**Our Case Number:** ACP-323980-25

**Re:** Proposed Water Supply Project for the Eastern and Midlands Region  
in the counties of Clare, Limerick, Tipperary, Offaly, Kildare, and Dublin.

## Observation on a Strategic Infrastructure Development Application

Drawing Title: RAW WATER RISING MAINS LAYOUT PLAN AND LONGITUDINAL SECTION (SHEET 1 OF 2)

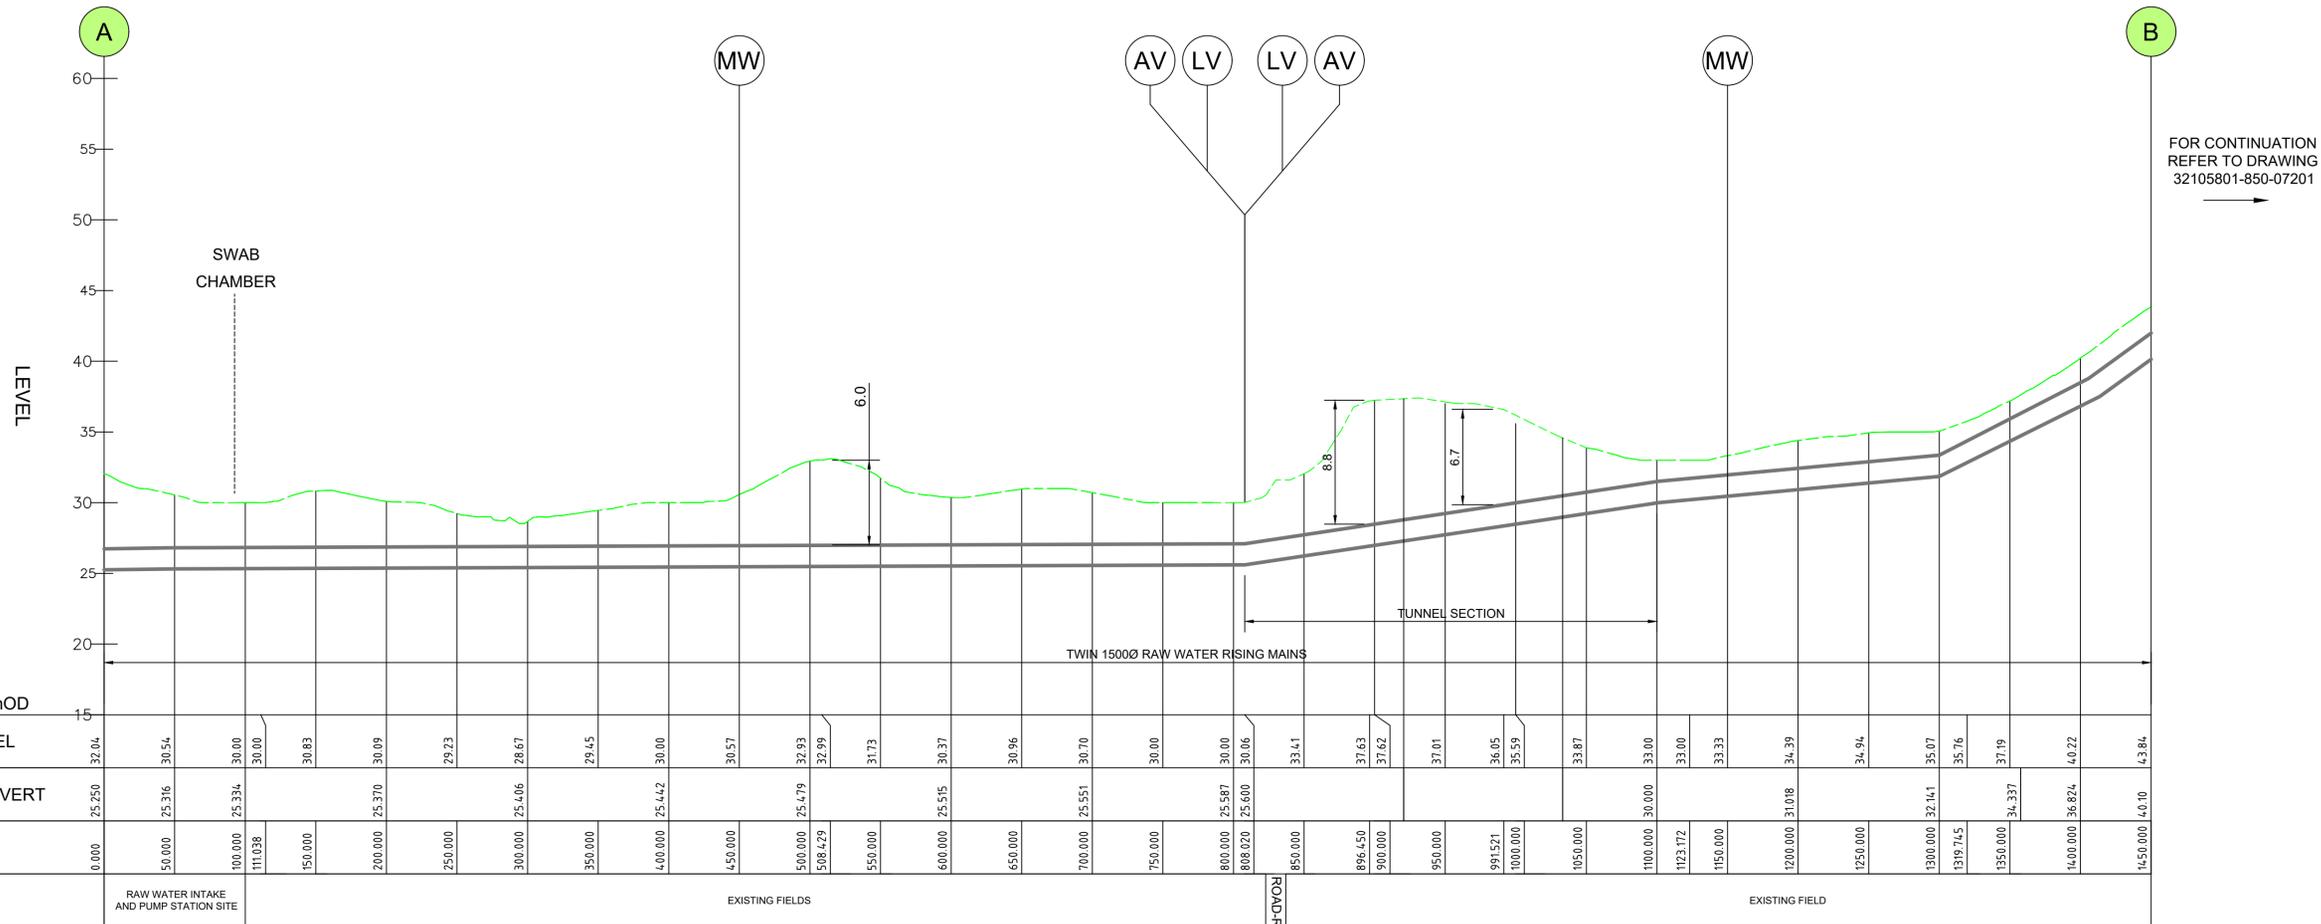
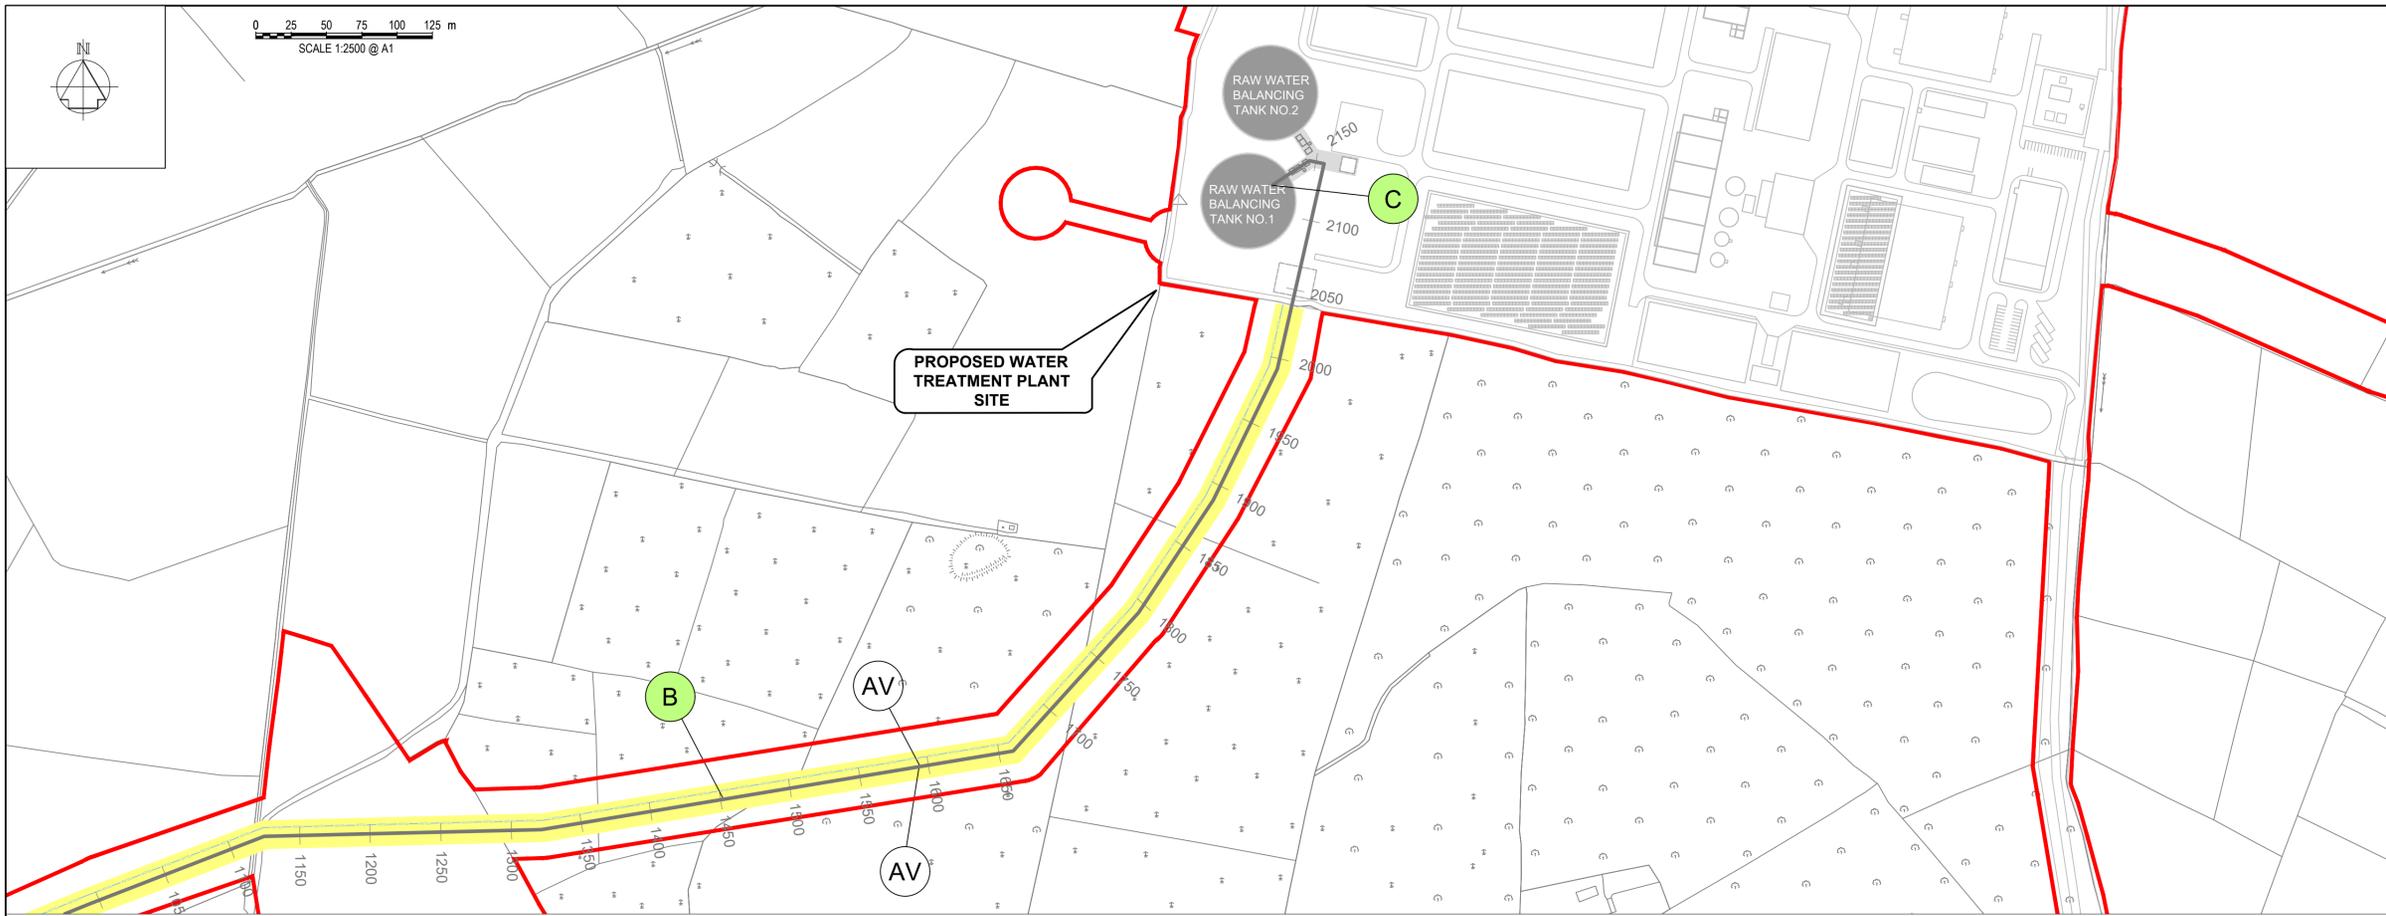
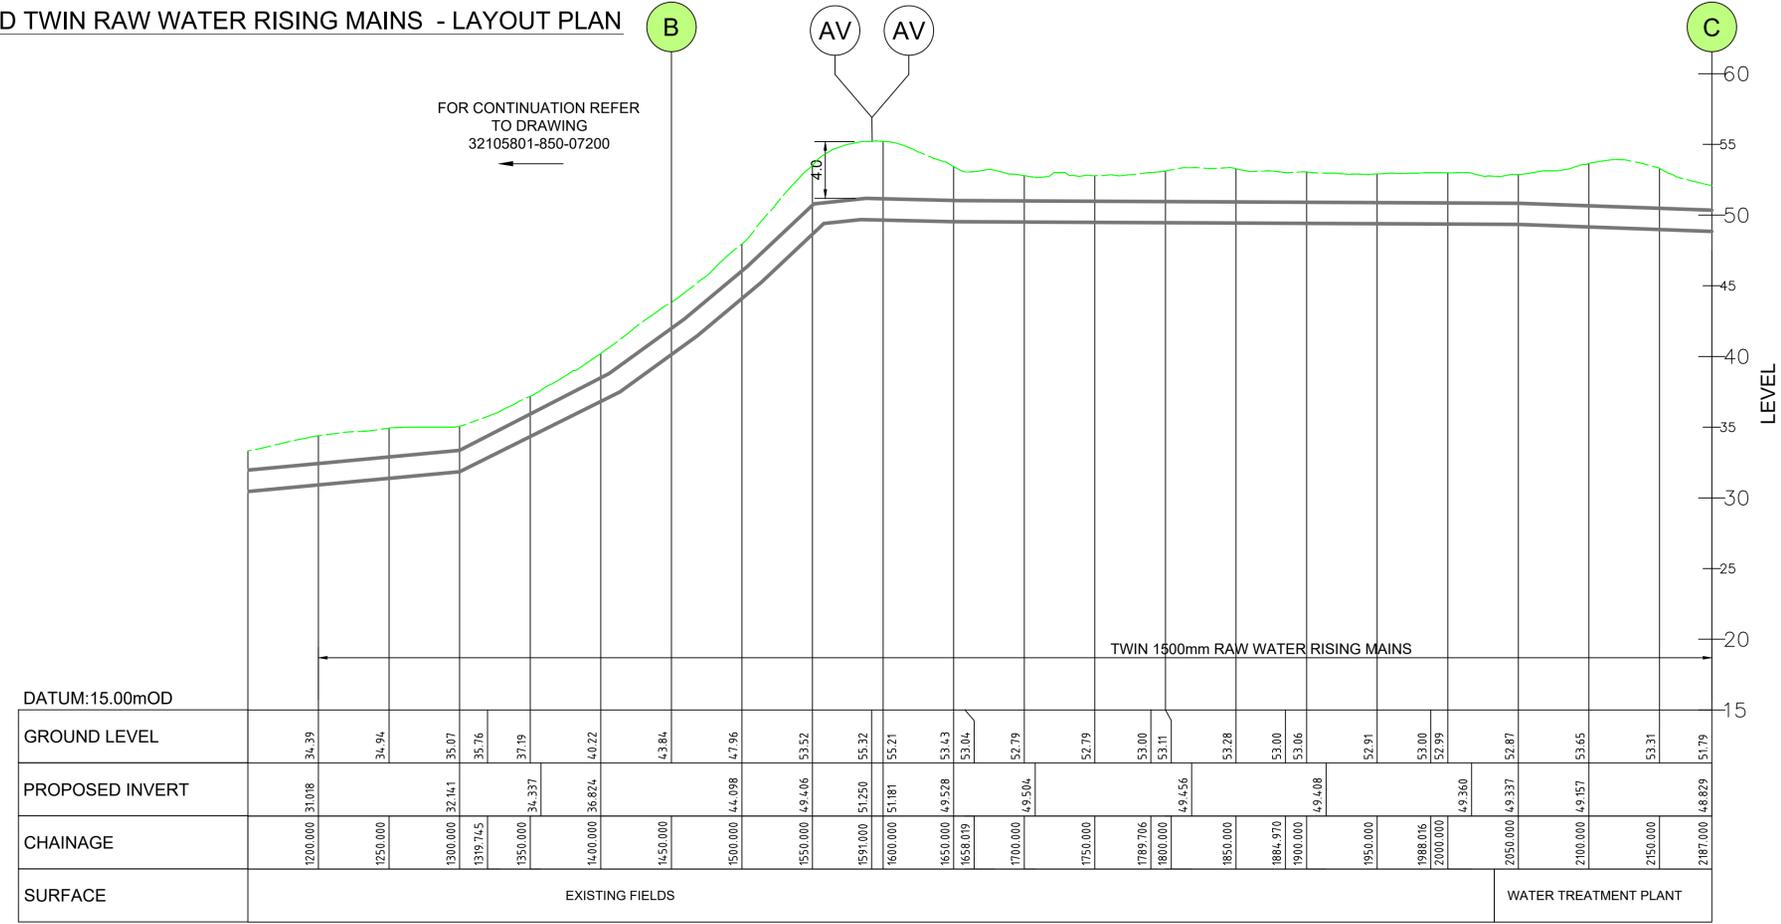
I object to the proposed 'underground' nature of the pipeline:

- Water is a force of nature. By burying the pipes and making good the route it will make maintenance of the system very difficult.
- New connections will be costly and difficult as future connection points will have to be accessed and excavated on private land.

Drawing Title
FIGURE 4.61
RAW WATER INTAKE
AND PUMPING STATION
PROPOSED SITE LAYOUT PLAN

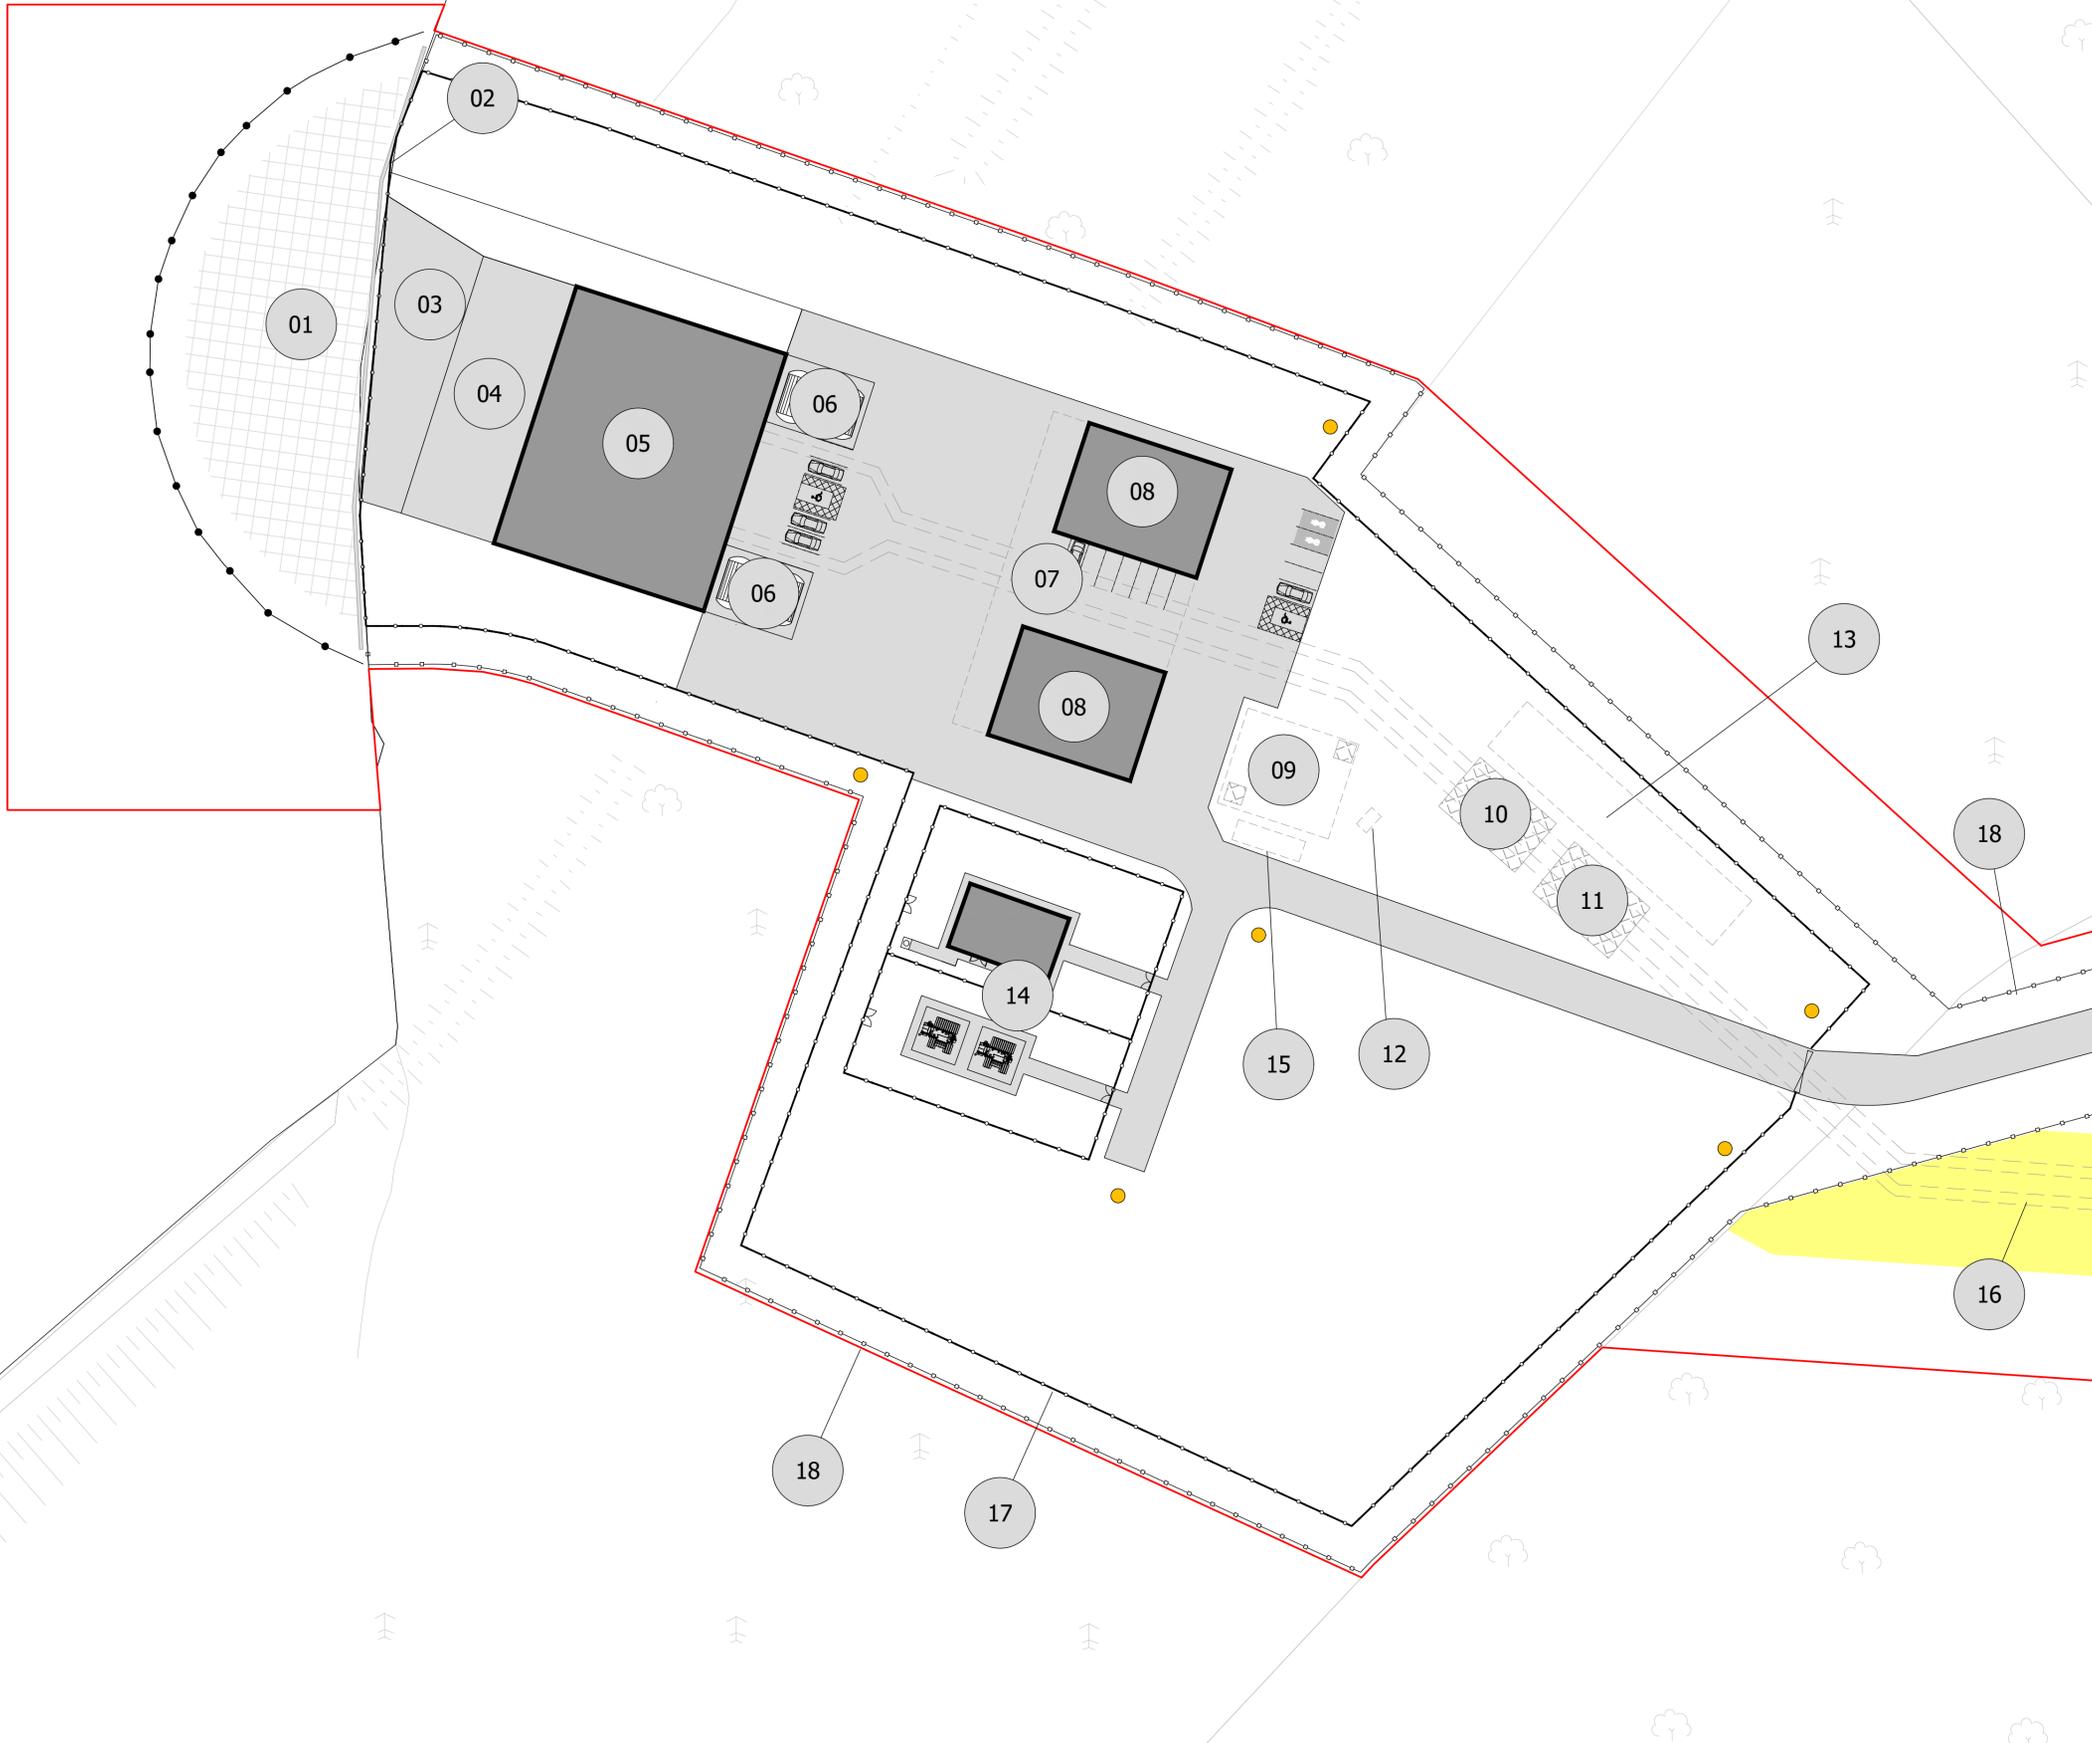
- It is my opinion that the location of the in-take of waters from the Parteen Basin is too close to the Ard na Crusha Hydroelectric Station. There are major issues with **flooding** and **water levels** in this area. Ard na Crusha influences this currently. The additional of another significant factor, i.e. the removal of tonnes of water from the

same immediate location is needless and will definitely impact the current situation.

I would request that the Board investigate the reasons for the location selected for the in-take station. I suggest that the relocation of the water intake station to Loch Ree will be beneficial on many grounds:
